**From:** Laura Tyler  
**Sent:** 05 January 2021 12:33  
**To:** Ben Williams  
**Subject:** RE: -20/01000/FUL Delrena  
**Attachments:** 050 PROPOSED SITE PLAN + BP.pdf

Title:
**Existing
Ground Floor Plan**

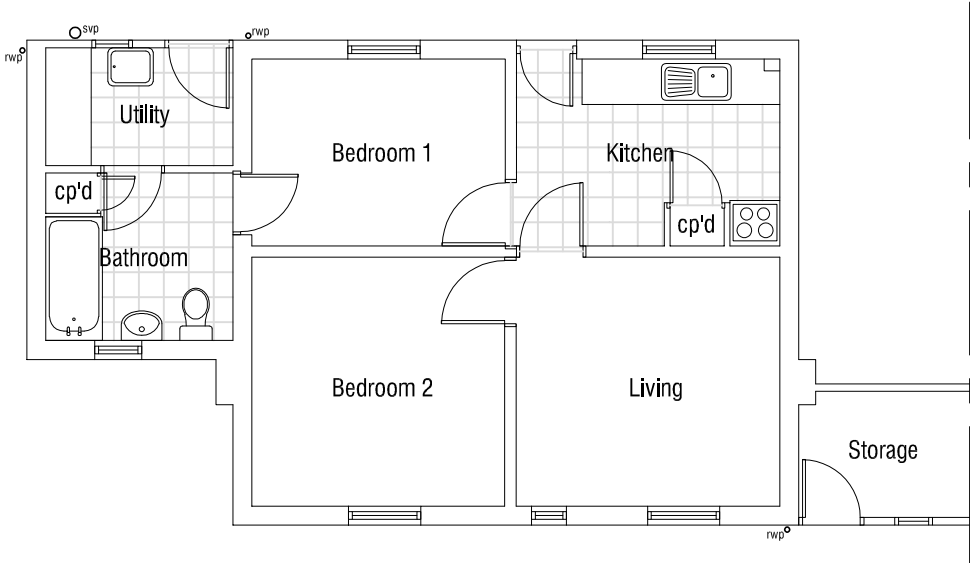
Also is the only entrance to the existing dwelling at the rear?

One other thing that has been picked up is the footprint of the dwelling as shown on the site location plan is different to that shown on the existing floorplan.
